COMMENT RESOLUTION FORM

Date:		3/30/2022		Disposition Codes:							
FHU Project Number		117253-08 EPC Reviews 2022		A. Accept Comment			E. Comment Conflicts with Previous Direction				
Project Name:		Briargate Blvd over Sand Creek Bridge		B. Delete Comment			F. Designer to Evaluate Comment				
Project Number:		EPC PCD CDR2113		C. Clarify Comment			G. Discuss Comment; Follow-up Required				
Client:		El Paso County		D. Disagree with Comment							
Designer:		Kiowa Engineering Corporation									
Submittal:		Review 2		Other Review:			N/A				
Reviewer Comments				Designer/Consultant Response				Final Disposition

C101

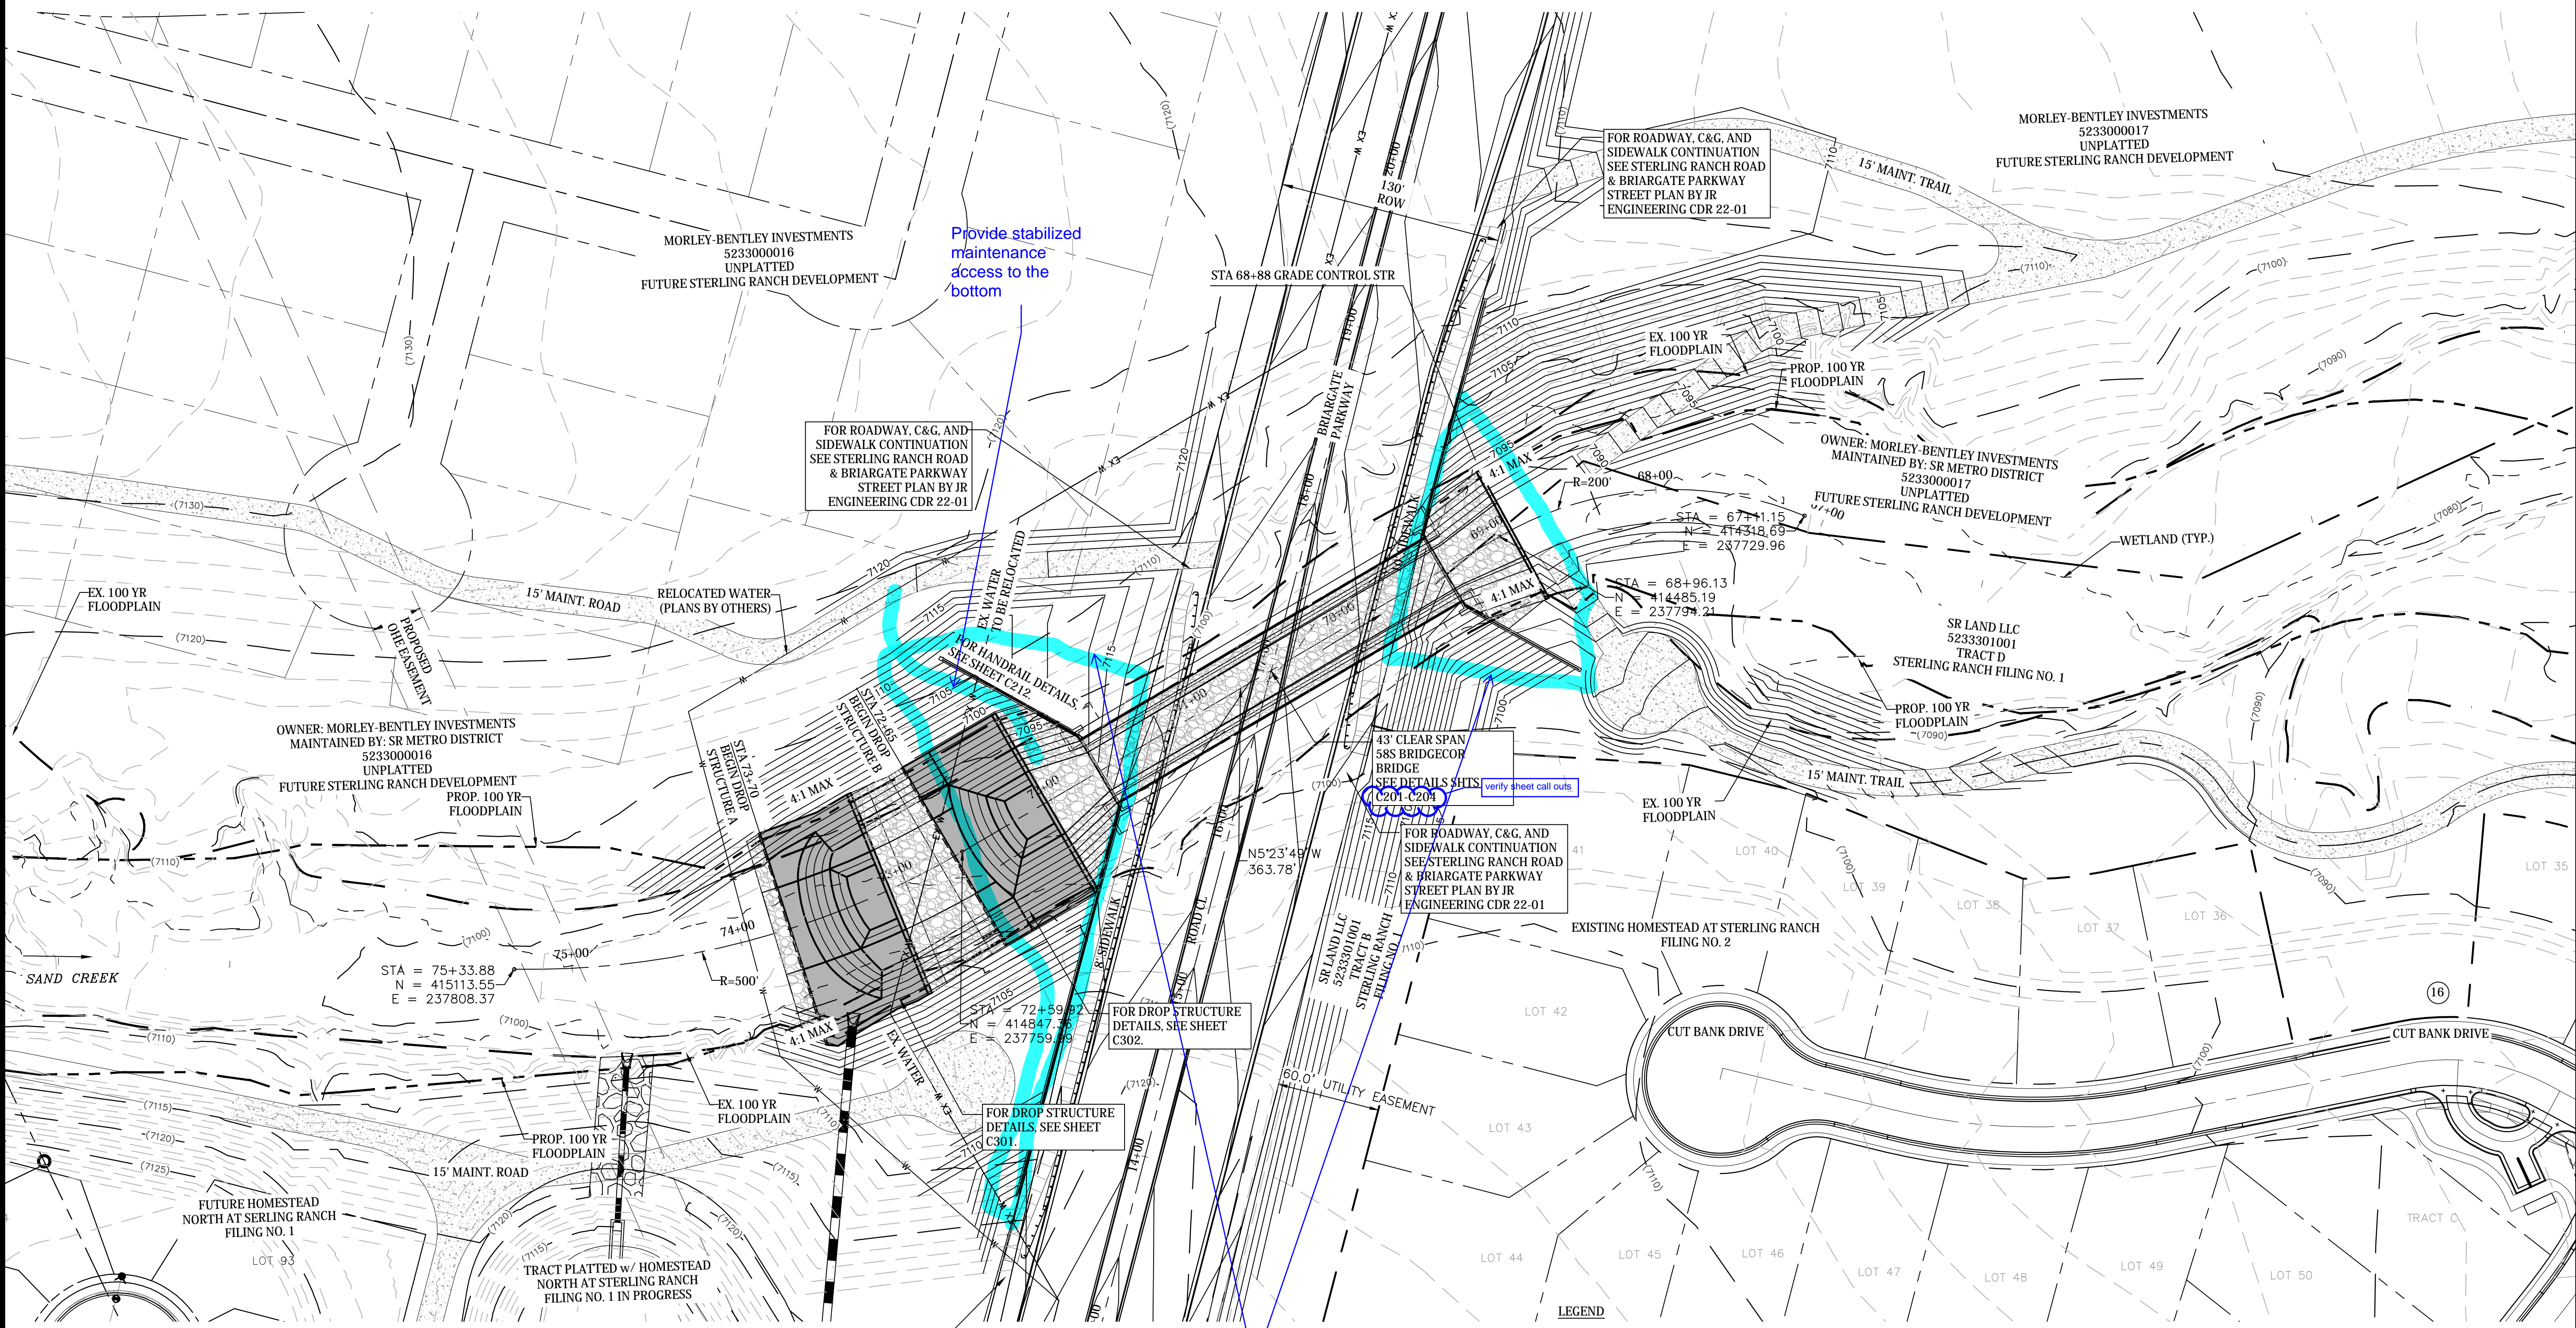
Comment No.	Reviewer	Sheet/ Page No.	Comments	Initial Code	Date	Response	Code	Date	Initials	Notes	
1	CAO	General	North arrow style is inconsistent throughout plans set	C. Clarify Comment		Is this relevant? There are multiple designers on this project and north arrow style does not add value or clarity to the design. Please clarify if you want Grid, Magnetic or True north	B	5/12/2022	CAO	Traditionally multiple designers on a project make plans look fairly consistent for ease of review and use in the field.	
2	CAO	General	Section cut style is inconsistent throughout plans set	C. Clarify Comment		Is this relevant? There are multiple designers on this project and north arrow style does not add value or clarity to the design.	B	5/12/2022	CAO	Traditionally multiple designers on a project make plans look fairly consistent for ease of review and use in the field.	
3	CAO	C101	verify sheet callouts	A. Accept Comment		plans are updated	A	5/12/2022	CAO

**STERLING RANCH DEVELOPMENT
BRIARGATE BOULEVARD BRIDGE CONSTRUCTION DRAWINGS
STRUCTURE LAYOUT**
EL PASO COUNTY, COLORADO

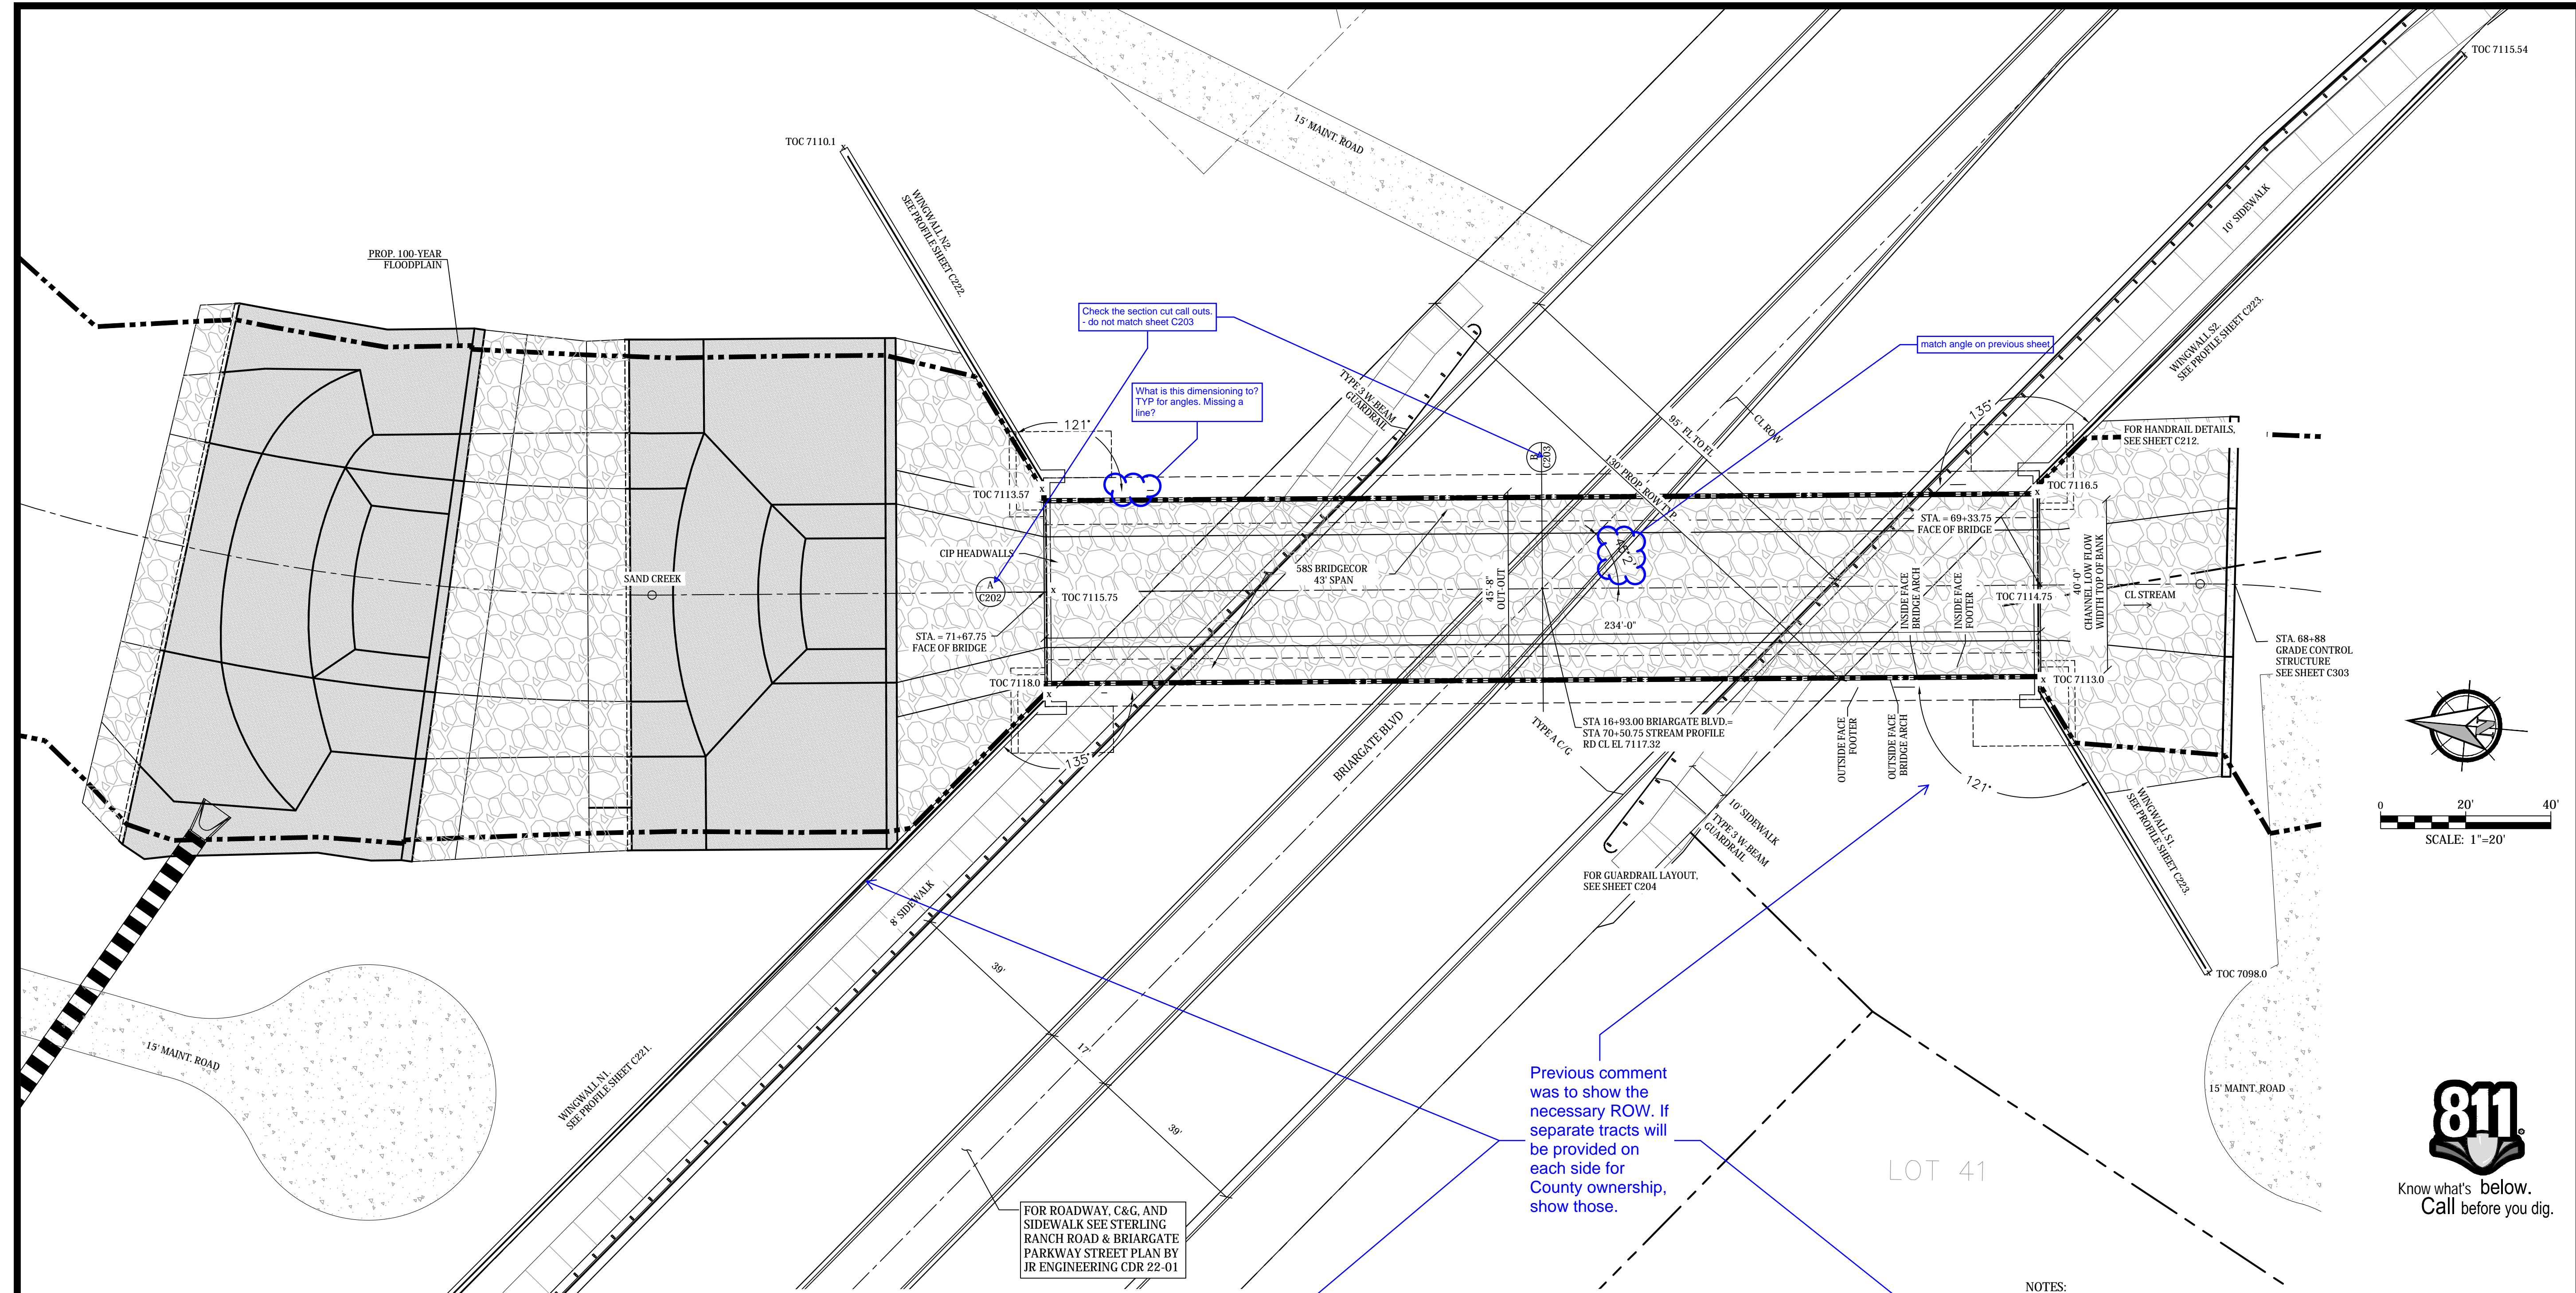
4	CAO	C202	Check the section cut call outs - do not match sheet C203	A. Accept Comment		plans are updated	A	5/12/2022	CAO		
5	CAO	C202	What is this dimensioning to? TYP for all angles. Missing a line?	A. Accept Comment		plans are updated	A	5/12/2022	CAO		
6	CAO	C202	Match angle on previous sheet.	A. Accept Comment		plans are updated	A	5/12/2022	CAO		
7	CAO	C202	not all TOC WW elevations shown on this sheet match what is shown in WW profiles.	A. Accept Comment		plans are updated	A	5/12/2022	CAO		
8	CAO	C203	Confirm this matches CONTECT details or backfill.	A. Accept Comment		Confirmed	A	5/12/2022	CAO		
9	CAO	C203	confirm backfill in this area is correct and matches that needed for arch and wingwalls/headwalls.	A. Accept Comment		plans are updated	A	5/12/2022	CAO		
10	CAO	C203	detail is below and not on CONTECH plans	A. Accept Comment		plans are updated	A	5/12/2022	CAO		
11	CAO	C203	confirm all dimensions with wingwall plans and detail/schedule sheets	A. Accept Comment		plans are updated	A	5/12/2022	CAO

12	CAO	C203	Check the section cut call outs - do not match sheet C202	A. Accept Comment		plans are updated	A	5/12/2022	CAO		
13	CAO	C203	detail is to the right and not on CONTECH plans	A. Accept Comment		plans are updated	A	5/12/2022	CAO		
14	CAO	C221	confirm that footing base is 36" below finished grade for frost protection in all locations (ref geotech report).	A. Accept Comment		plans are updated	A	5/12/2022	CAO		
15	CAO	C224	3' minimum is typically to bottom of footing	A. Accept Comment		plans are updated	A	5/12/2022	CAO		
16	CAO	C224	I do not see this called out in the geotech report; what would be the thickness of this?	A. Accept Comment		plans are updated	A	5/12/2022	CAO		
17	CAO	C224	Is this title correct?	A. Accept Comment		plans are updated	A	5/12/2022	CAO		
18	CAO	C224	Is this what you are referring to as a cold joint on the WW profile views. Does this apply to both horizontal and vertical joints? Why is this different than the headwalls?	A. Accept Comment		plans are updated	A	5/12/2022	CAO

C231

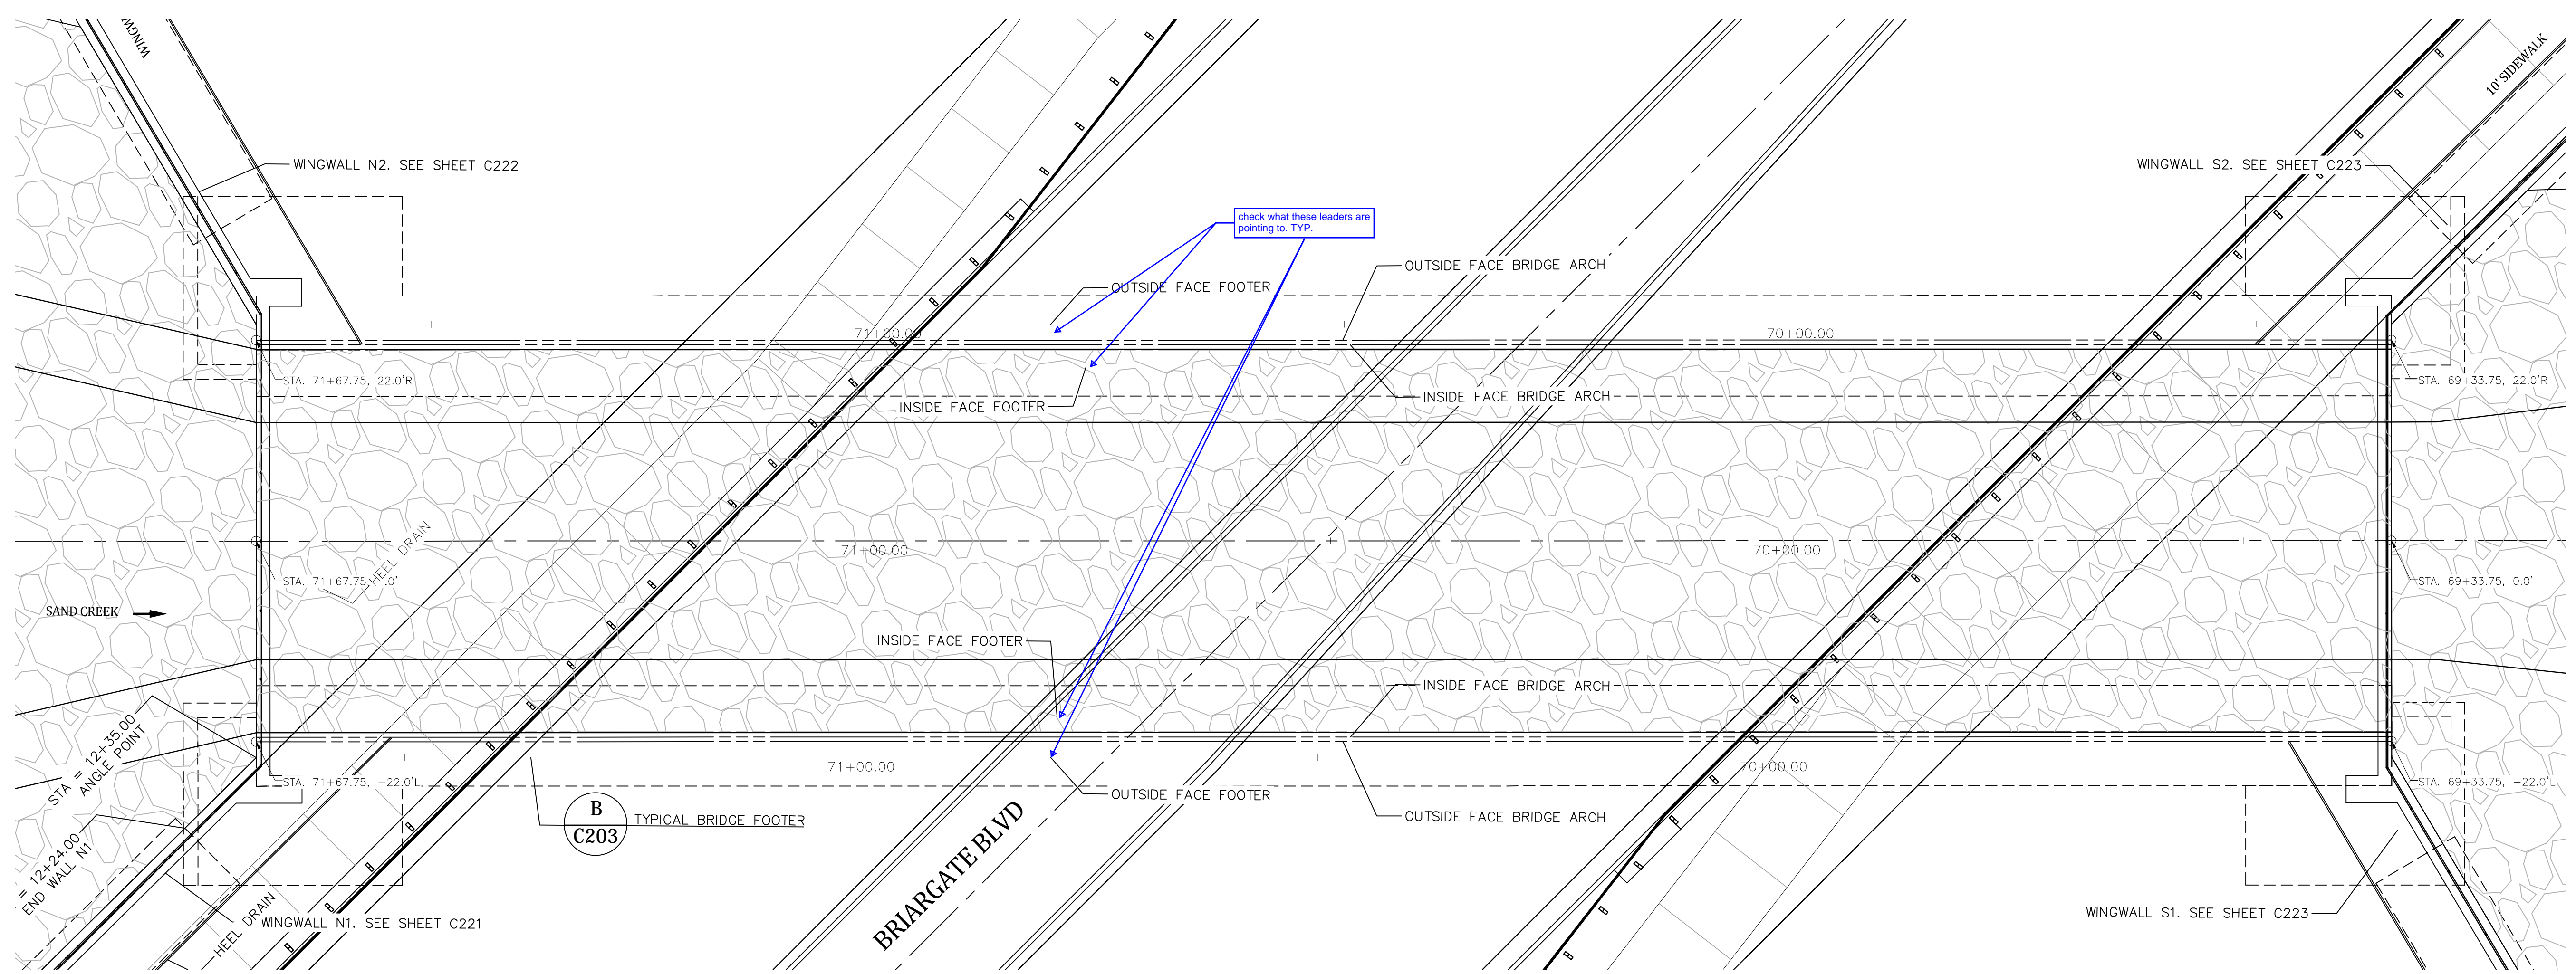
19	CAO	231	check what these leaders are pointing to. TYP.	A. Accept Comment		plans are updated	A	5/12/2022	CAO		
20	CAO	Headwall general	Headwall design and detail sheet appear to be incomplete	A. Accept Comment		plans are updated	A	5/12/2022	CAO		
21	CAO	Misc Headwall Details	Confirm this is the weakened plane noted in elevation view.	A. Accept Comment		plans are updated	A	5/12/2022	CAO		
22	CAO	CONTECT Sheet 3	angles do not match structure layout	A. Accept Comment		plans are updated	A	5/12/2022	CAO		
23	CAO	CONTECT Sheet 5	is a line missing?	A. Accept Comment		plans are updated	A	5/12/2022	CAO		
24	KMG	C201	C303 callout should be C311 callout	A. Accept Comment		plans are updated	A	5/18/2022	KMG
